31/03/2016 Ref: BFC-AFP113

CONFUSION, INEPTITUDE & INCOMPETENCE REIGNS
APPLICATION BY WPD FOR A DEVELOPMENT CONSENT ORDER

A116 A117	FGC - 378036
RHIF Y CYNLLUN / PLAN NUMBER:	HoT BF ID 648 1of 1
GRADDFA / SCALE:	1:2500 @ A3
DYDDIAD / DATE:	02 09 2015

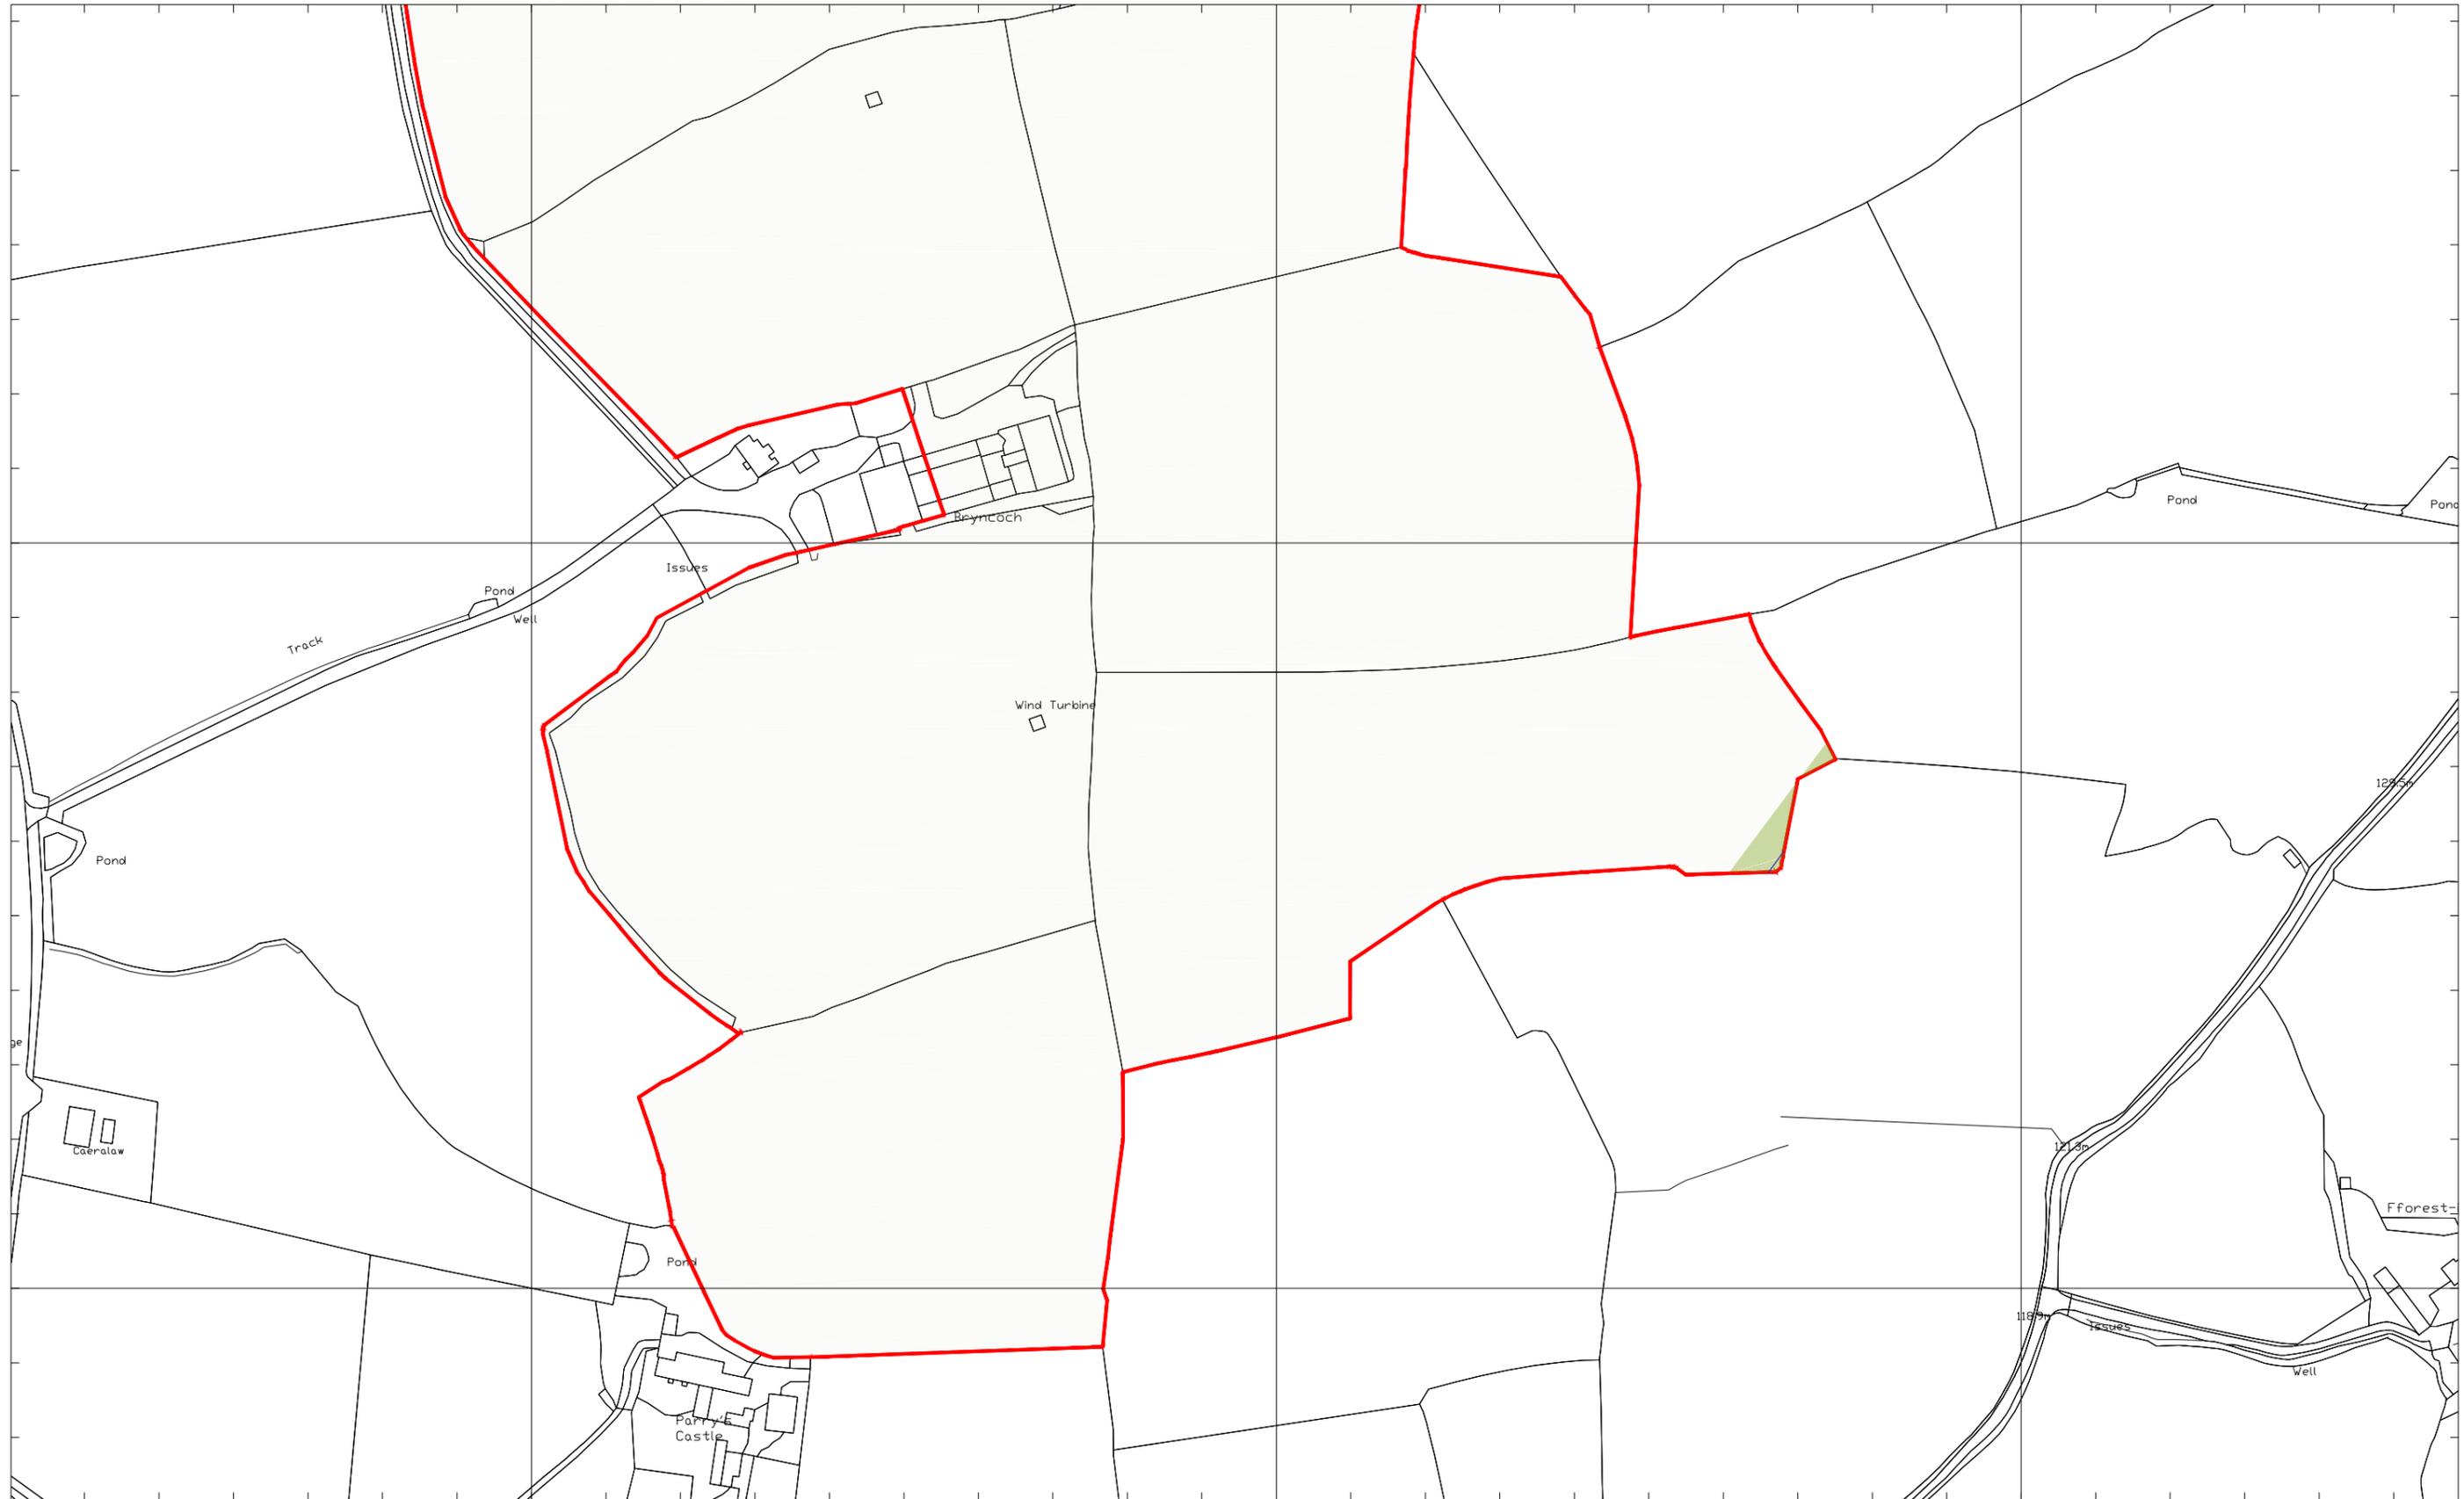
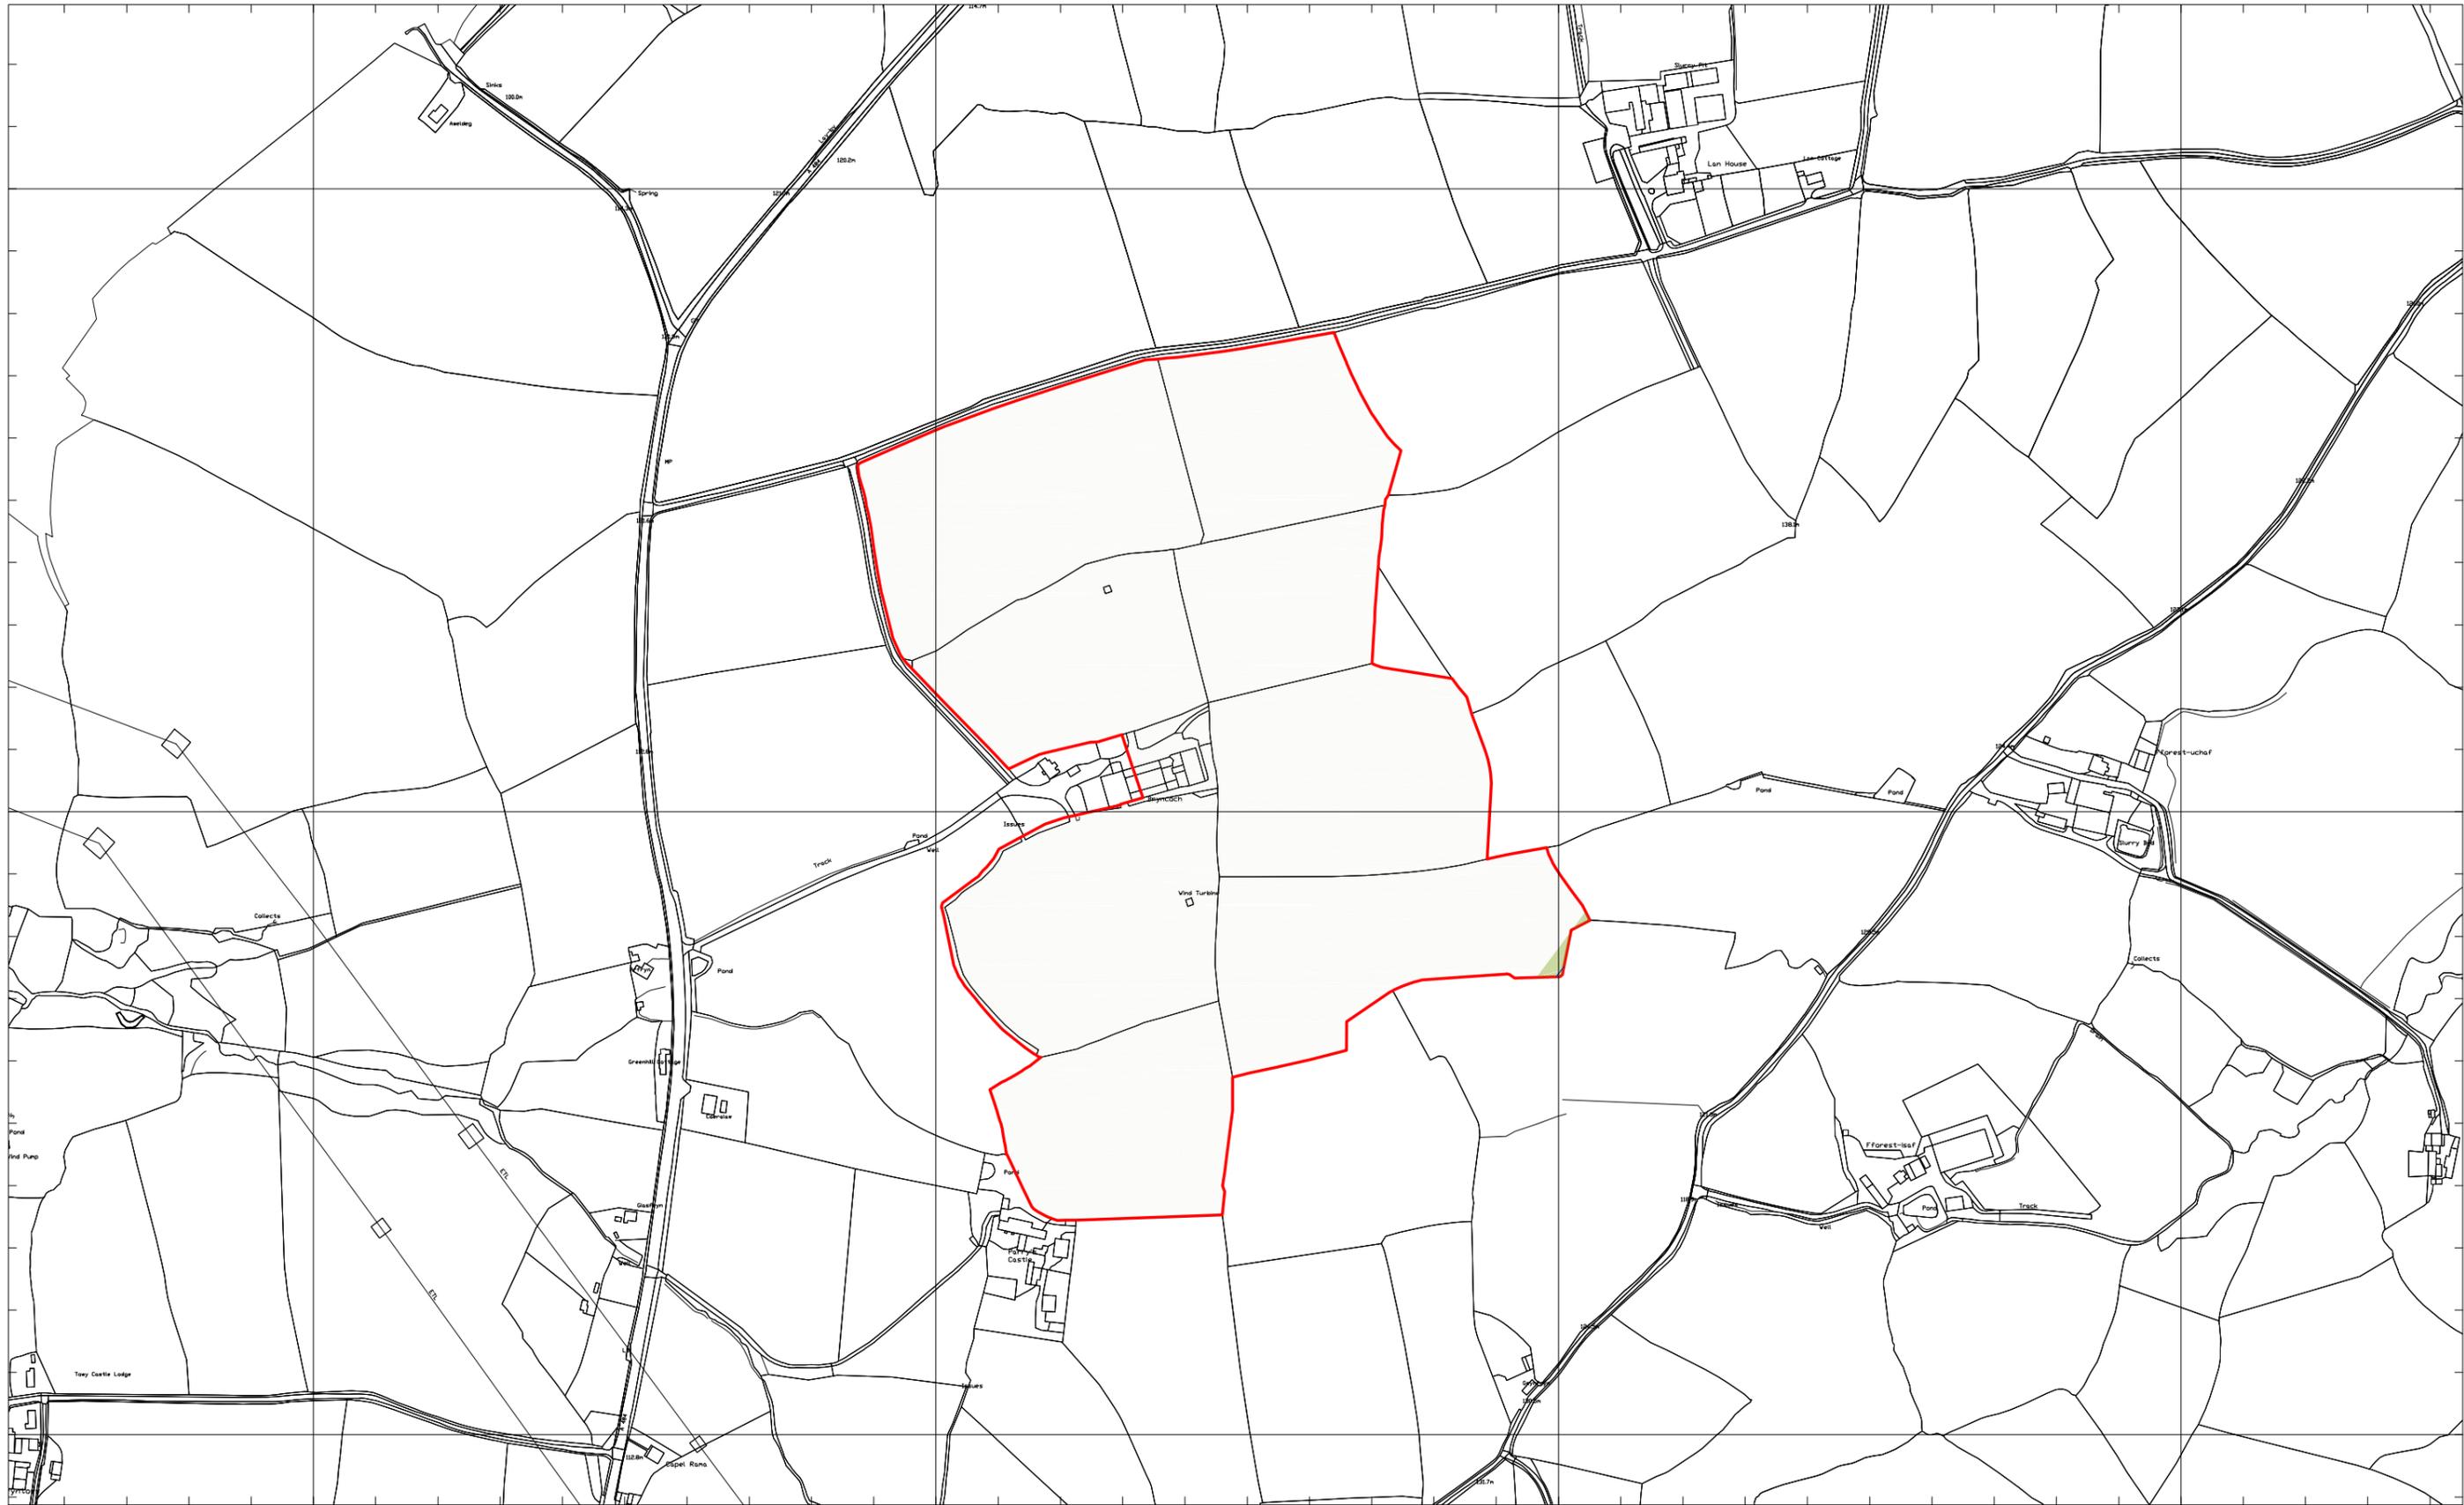
Our property HoT as Mr Jones has pointed out on many previous occasions requires a right of way for the applicant to access Pole 169. There is no requirement for a property wide demise area on our retained property.

The enclosed key terms sheet, heads of terms and the amended plan of our property are still incorrect. Did Mr Buxton ever refer to the plan provided to the Inquiry on the 17th February 2016. I refer to previous plans and the previous correspondence we sent to you. Does Mr Buxton ever read what goes on with PINS as he is always criticising Mr Jones for not detailing landowner's concerns.

Whilst I see that WPD have reduced their unreasonable request to control my entire property, the extent of the demise area is beyond that which is proportionate for the development.

2. There is no requirement for an easement area. For the avoidance of doubt on the plan of my property Mr Buxton provided with his letter I notice there is an area coloured brown outside the front of my house which in fact encompasses the steps up to my house and part of my patio, pond and garden and 180 plus trees to our private dwelling.

3. WPD have already surveyed and identified the best access route to Pole 169 which is an existing road. Please delete reference to the easement area. This is not required and is not proportionate to your development as you already have access to an existing road. WPD do not need anything else – what can be better than an existing metalled road.

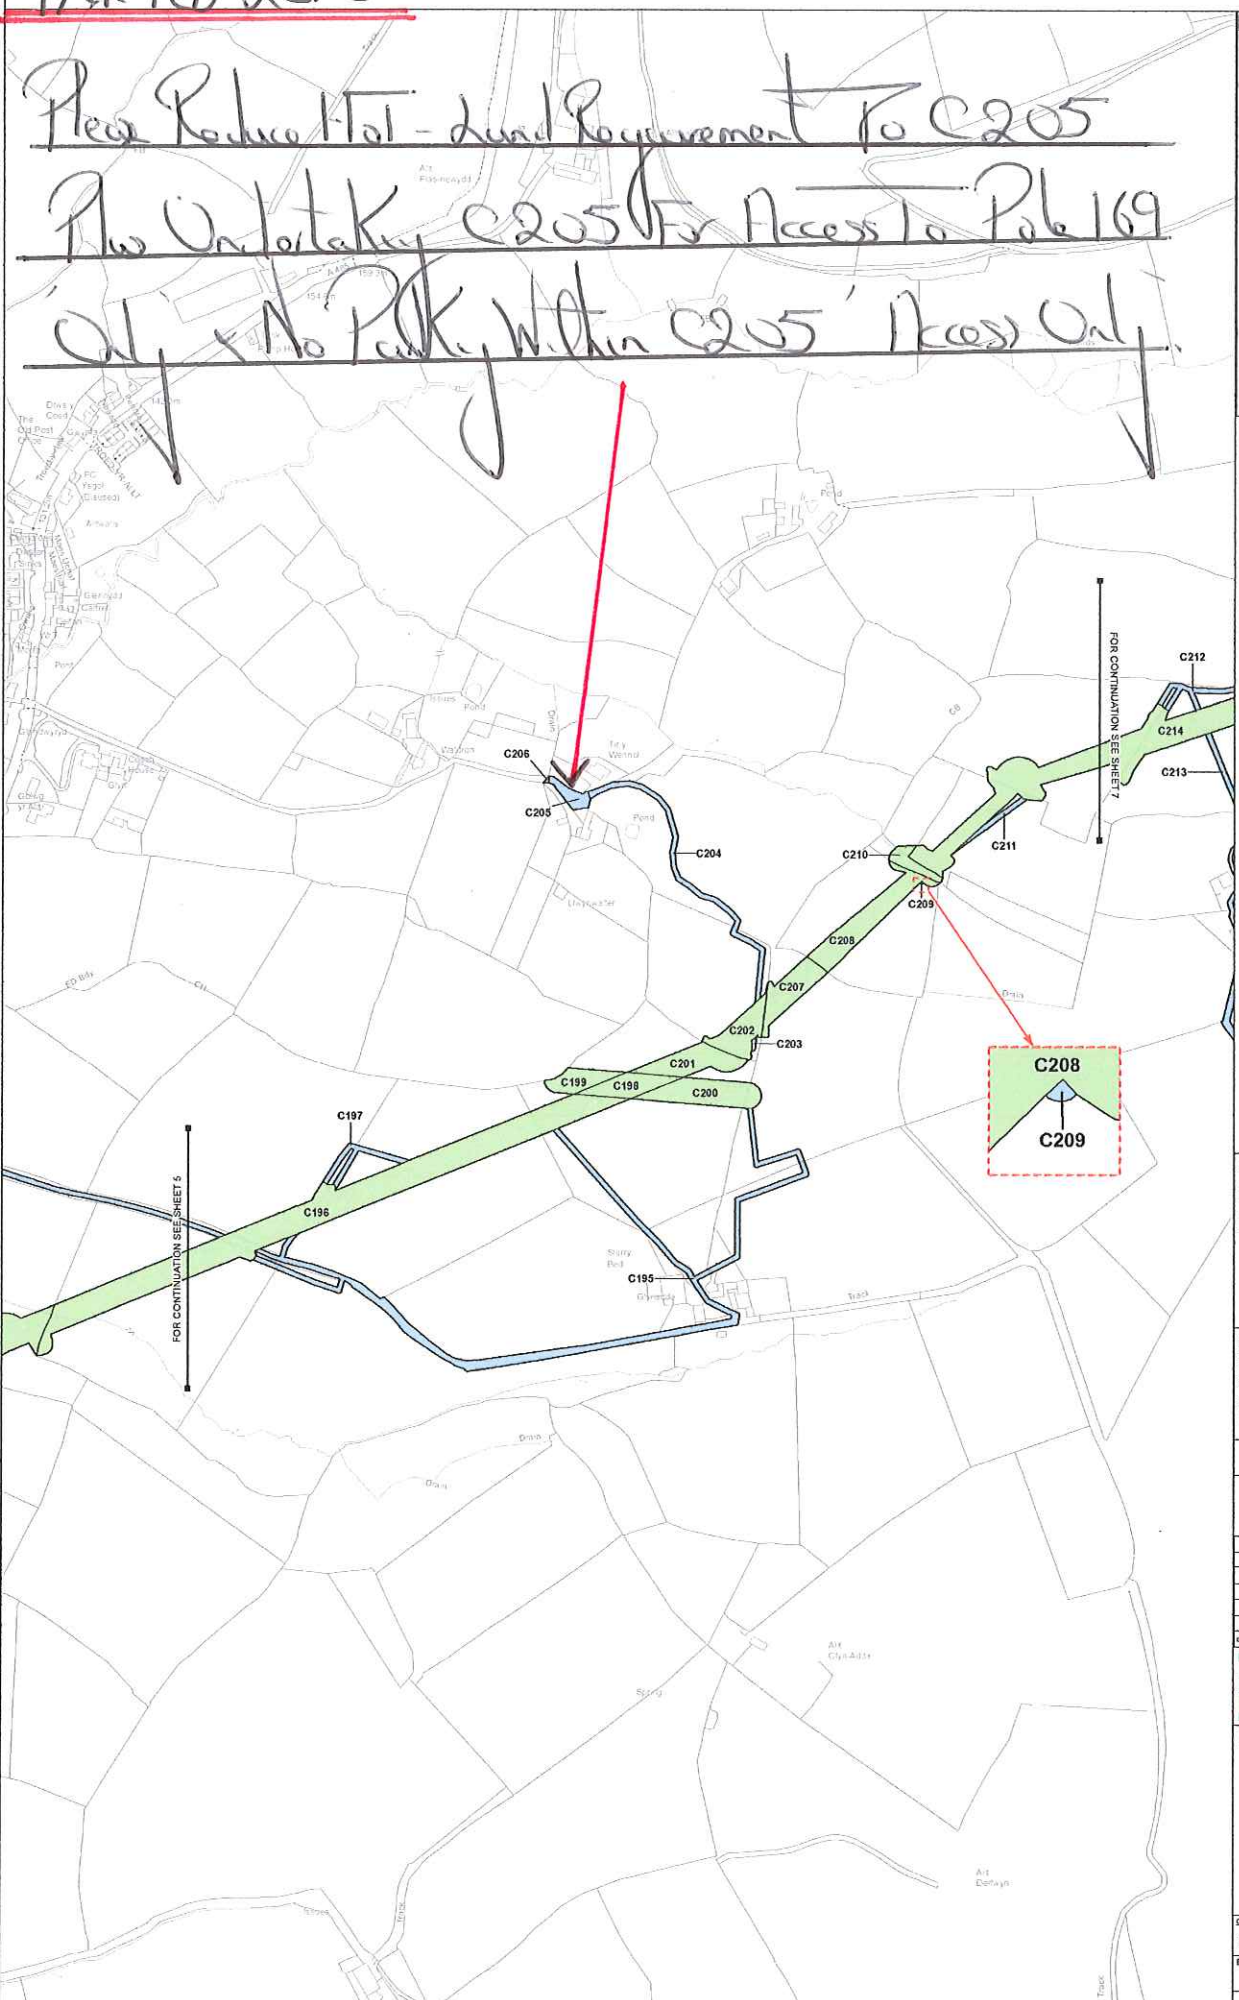
- I contacted Mr Jones and went to his office the same day. Mr Jones corrected the plan and provided 2 new plans based on the plan provided by WPD. The first plan he produced identified the correct boundary position in red and marked in yellow for the avoidance of doubt the land interests we do not own. He also corrected on Plan 1 the appropriate features of our PWS and highlighted the revised position of poles 170 & 171 as agreed with WPD but not reflected in Mr Buxton's letter or on the plan attached. Mr Jones also provided a second plan identifying our track and confirming access to pole 169 only with no parking in our driveway. These were previously submitted to PINS.

- The revised HoT does not reflect what was agreed and WPD have not corrected the hydrology plan as corrected by Mr Jones or modified the HoT to reflect what is required. We cannot sign the revised HoT in its current guise as it is still incorrect as we will point out below

When he visited me he listened but didn't really seem much interested with my concerns over the map. If he had been concerned, he would have walked the boundary like Mr Jones did and marked up an appropriate plan. The plan that Mr Jones prepared is already with PINS but the new plan attached to the HoT is still wrong and before long we will be accused of trying to claim Mrs Rentmores property.
